Appendix 1 Detailed Response to Issues Raised

Table 3. Detailed Response to Issues Raised in Further Submission from the City of Sydney

WINTER SOLSTICE 3PM ENVELOPE SHADOW

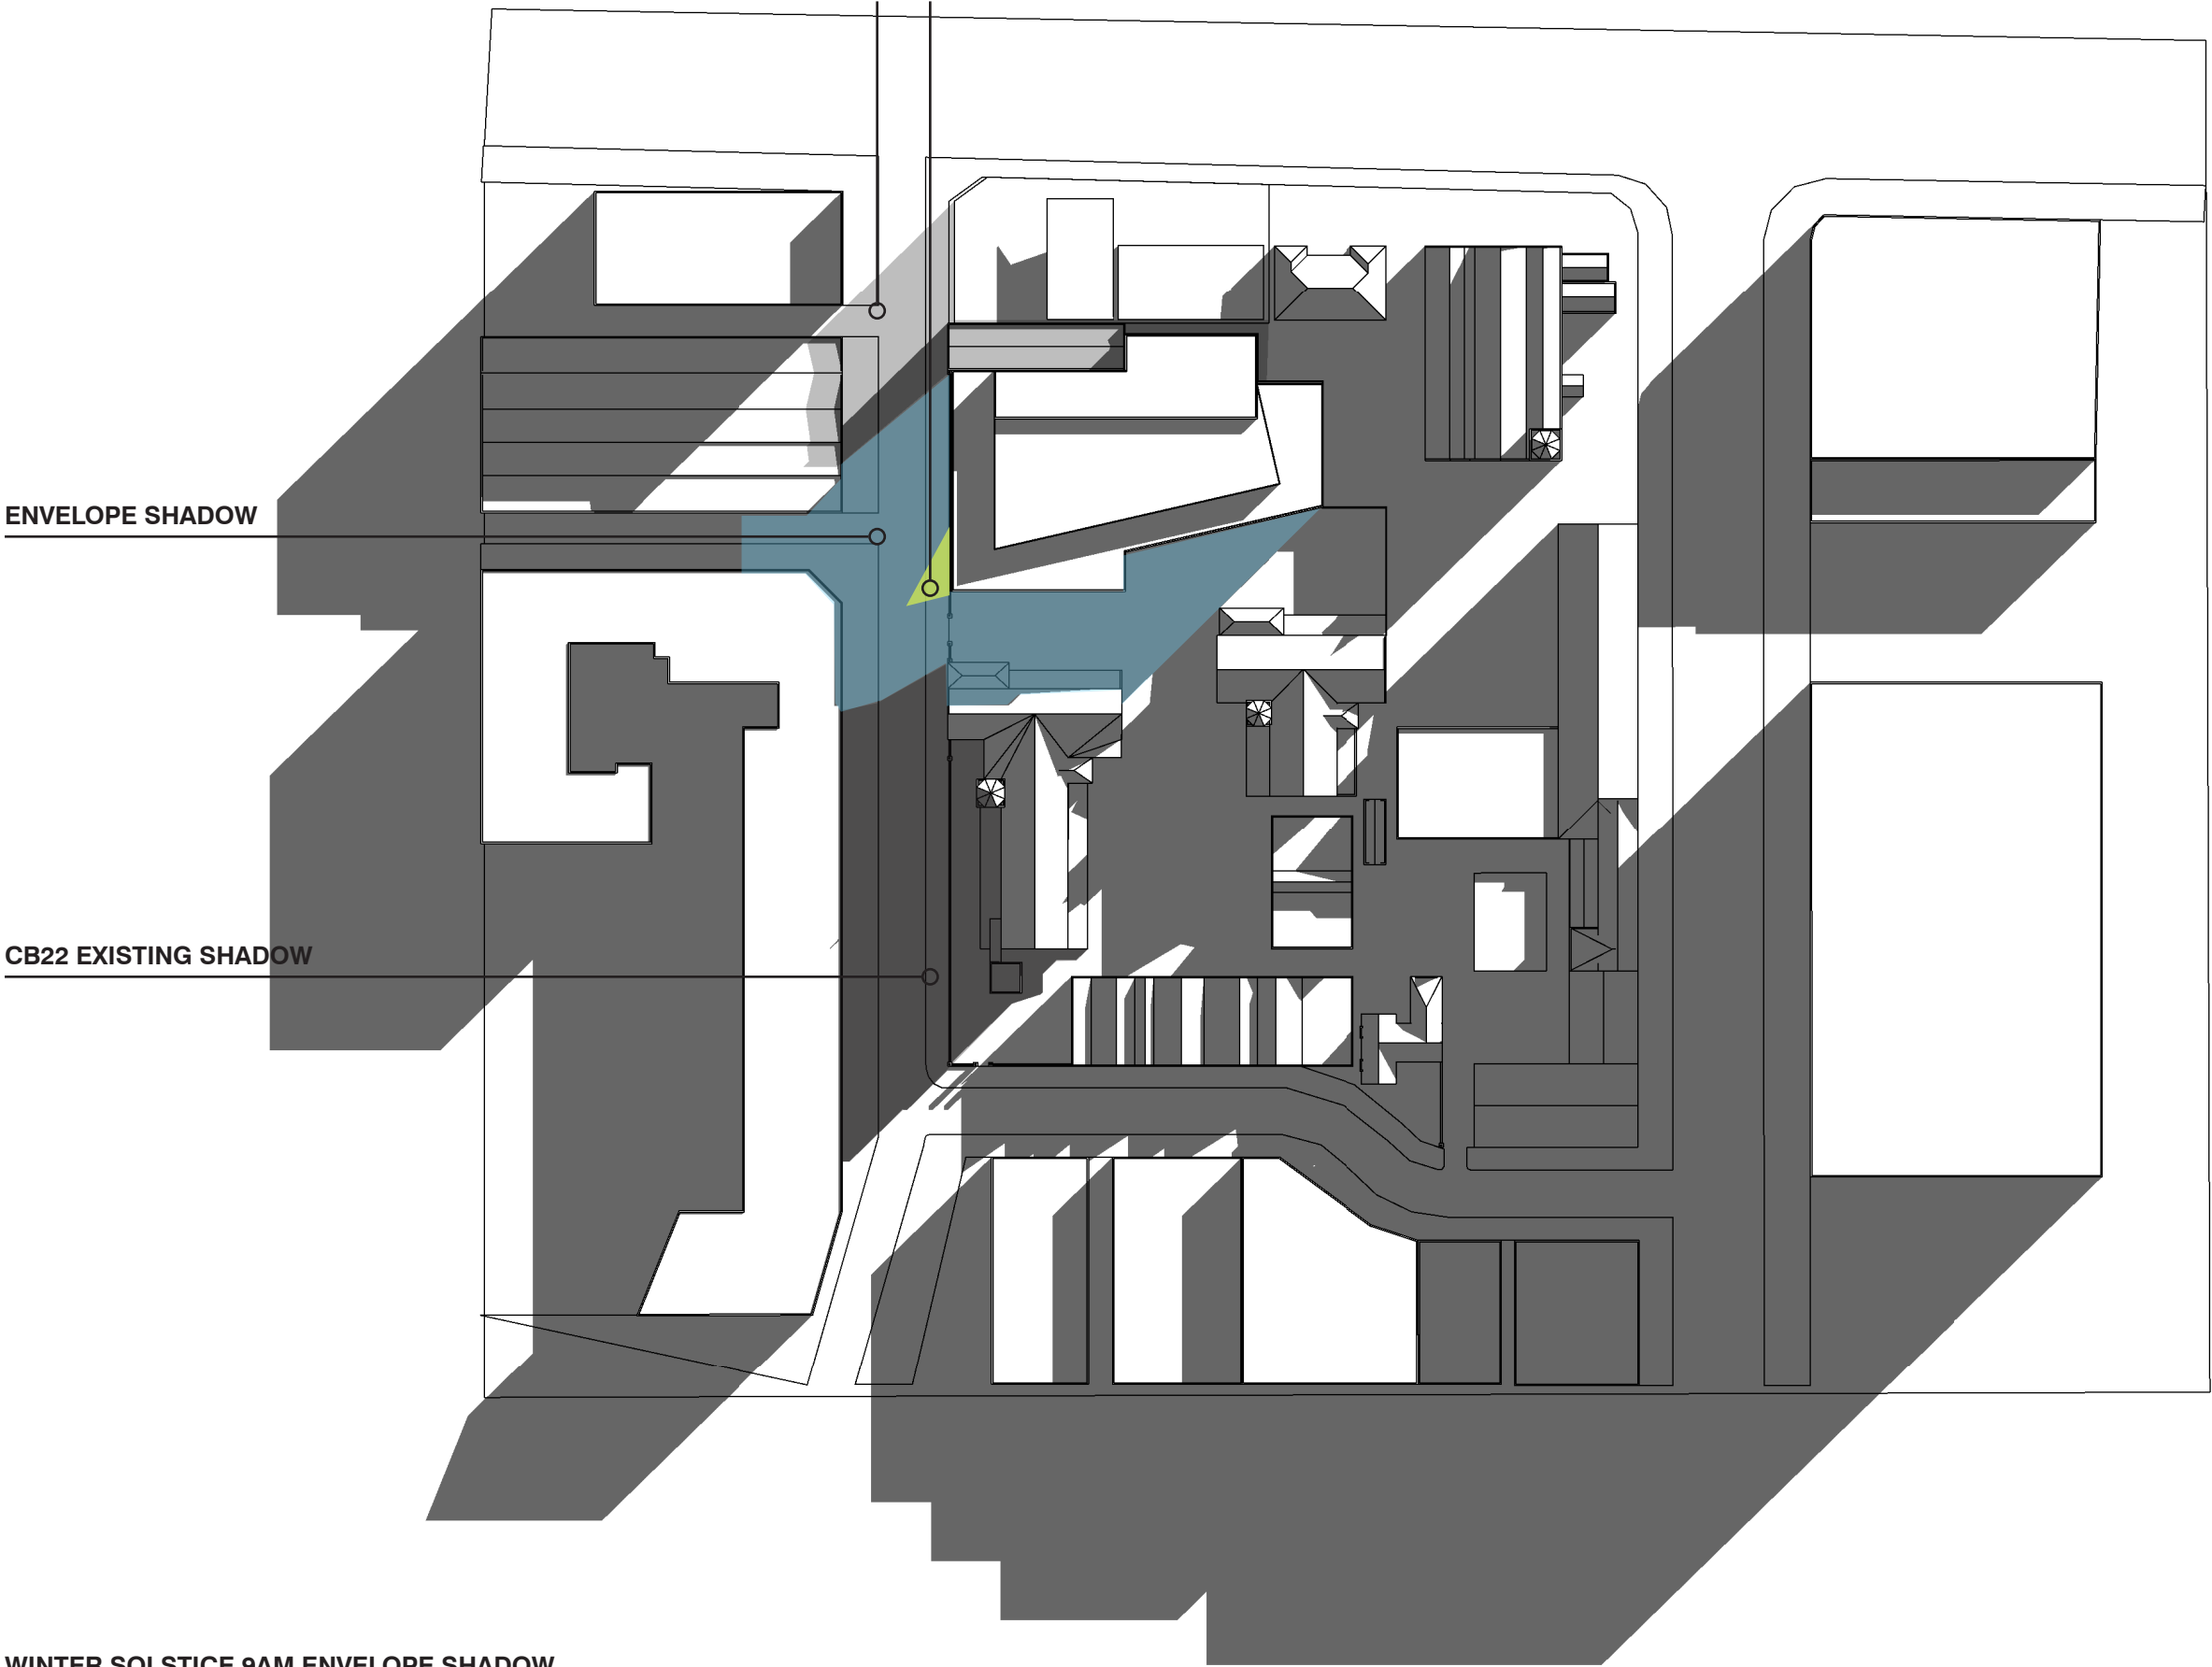
Overshadowing of UNDA Courtyard	<p>Further information required.</p> <p>A diagram indicating the midday shadows to UNDA should be provided as the current diagrams illustrate impacts between 1.00pm and 3.00pm only.</p> <p>The shadow diagrams show that there is a significant impact at 3.00pm caused by the height of the envelope at the eastern boundary. A reduction in height to two storeys with a setback greater than 2m as originally suggested, would improve sun access at 3.00pm.</p> <p>It is reiterated that the detailed design of the building must reduce, as far as practical, any additional overshadowing on the winter solstice to the external courtyard to the south of St Benedict's Church (UNDA campus).</p>	<p>The revised envelope has been designed to retain solar access to the UNDA courtyard, maintaining a very high degree of afternoon midwinter sunlight. As a result of the proposed changes, the courtyard will not receive any significant overshadowing as a result of buildings on the UTS site until after 2pm, ensuring that the courtyard receives excellent solar access at the critical lunchtime period. After 2pm, the amount of shadow gradually increases, and from approximately 2.30pm around one fifth of the courtyard is shadowed by the proposal. By 3pm the proposal shades approximately half of the courtyard, with solar access retained along the full diagonal of the courtyard from the north west to the south east.</p> <p>Revised shadow diagrams at half hourly intervals from 12noon and 3pm have been provided showing the existing situation and as proposed.</p>

It is considered that the UNDA courtyard (which is a private non-residential open space) retains an excellent level of amenity with the courtyard enjoying solar access for the entire afternoon, and with no significant impact until after 2pm, and with solar access retained to the full diagonal width of the courtyard by 3pm.
Height above 9m	<p>Objection.</p> <p>The revised envelope does not satisfy the urban design principles set out in the City's previous advice.</p> <p>Overshadowing impacts to the eastern façade of 2-4 Grafton Street and to the external courtyard to the south of St Benedicts Church (UNDA Campus) are still significant issues and require additional information to quantify the impact as noted above.</p>	<p>The urban design form of the proposed envelope addresses Council's urban design principles with setbacks to the heritage buildings, responses to the alignment of Grafton Street, further setbacks to the eastern boundary and further retention of the heritage fence all incorporated in the revised envelope.</p> <p>Overshadowing of the 2-4 Grafton Street is resolved with all windows in the eastern elevation unshaded after 9am, and the windows on the splayed corner (between Grafton Street and Buckland Street) demonstrated to have at least 2 hours of useful solar access in accordance with the SDG requirements and the Department's technical note regarding solar access requirements in SEPP 65.</p> <p>As discussed above, the UNDA courtyard, (which is a private non-residential open space) retains an excellent level of amenity with the courtyard enjoying solar access for the entire afternoon, and with no significant impact until after 2pm, and with solar access retained to the full diagonal width of the courtyard by 3pm. This is considered to be a minimal impact.</p>
